Your Ref: OWPC19377
Our Ref: AB/64/18/HH 12-06-2018
Please ask for:
Zac Denton

Single storey rear extension with balcony at first floor level.
16 Dalloway Road Arundel

drawing
Floor Plans and Roof Plan
As Proposed

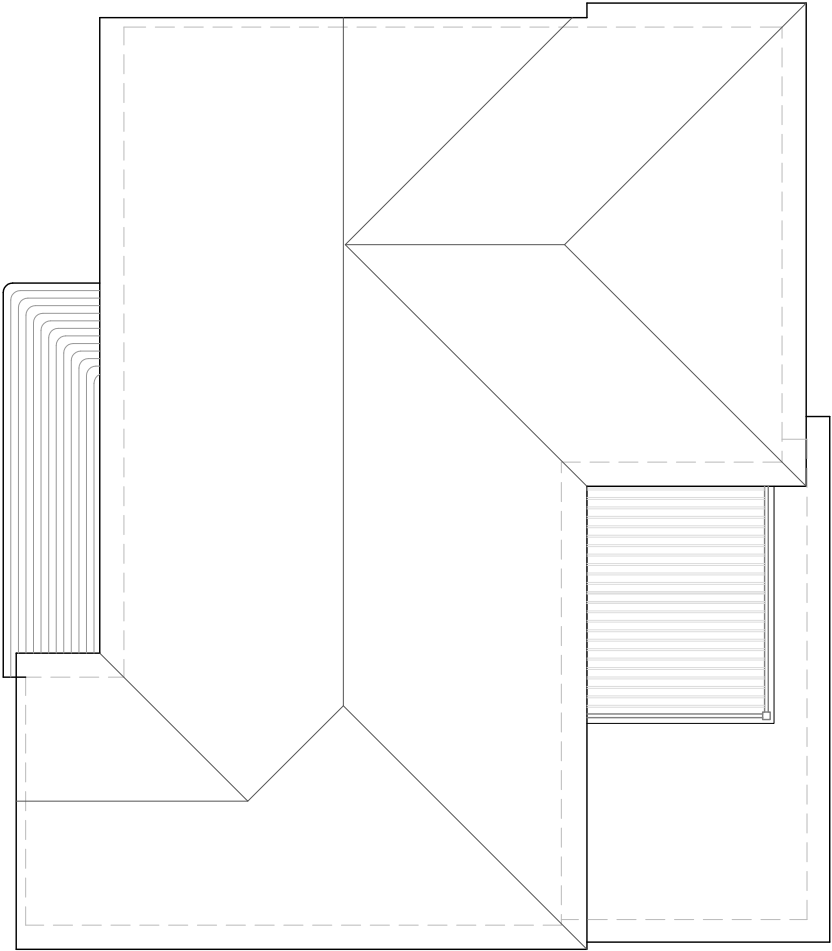
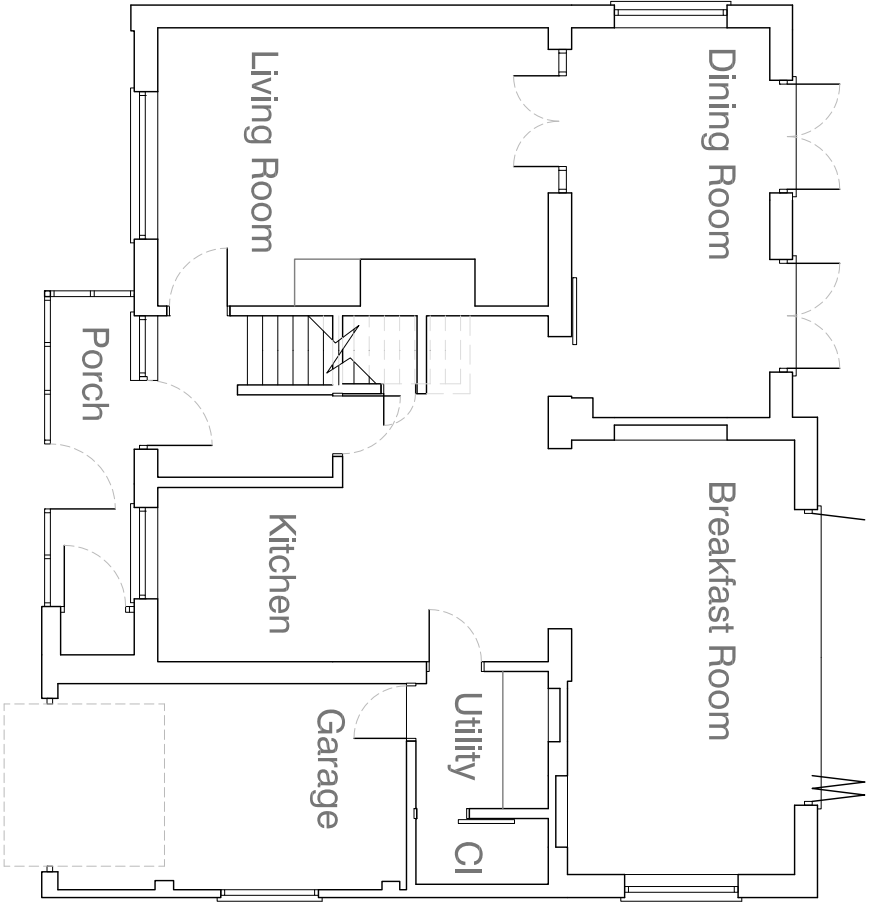
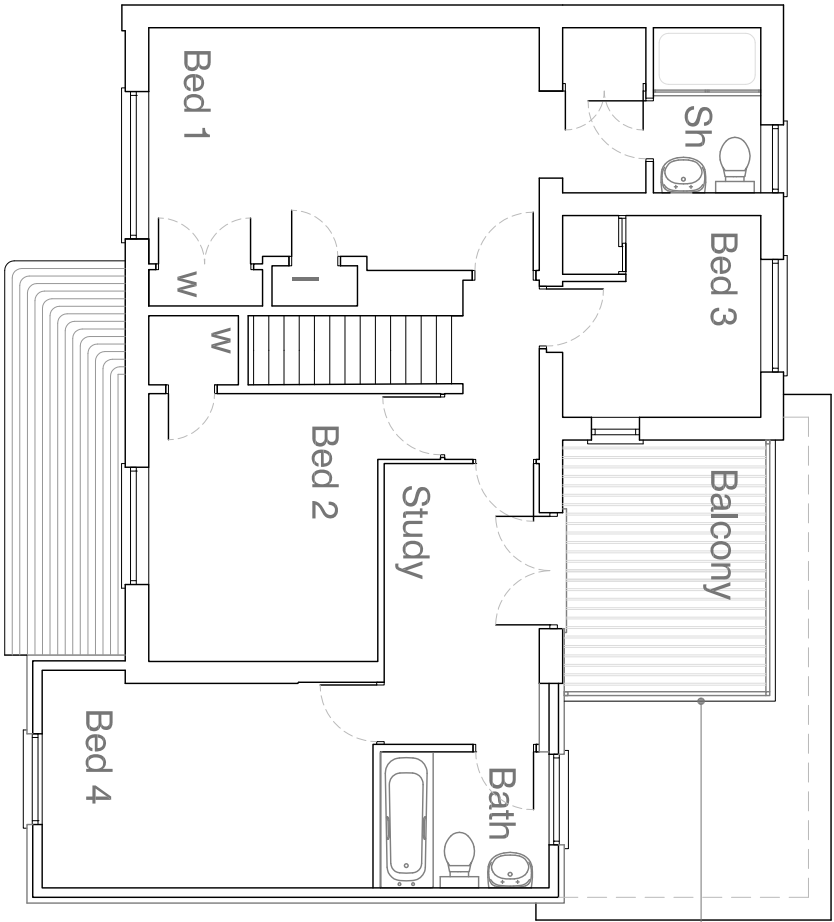
On a previous application for a balcony on the 1st floor rear of no 16, following an inspection by a Planning Officer, it was required that a screen be incorporated for the sake of privacy to the bedroom of no 14.
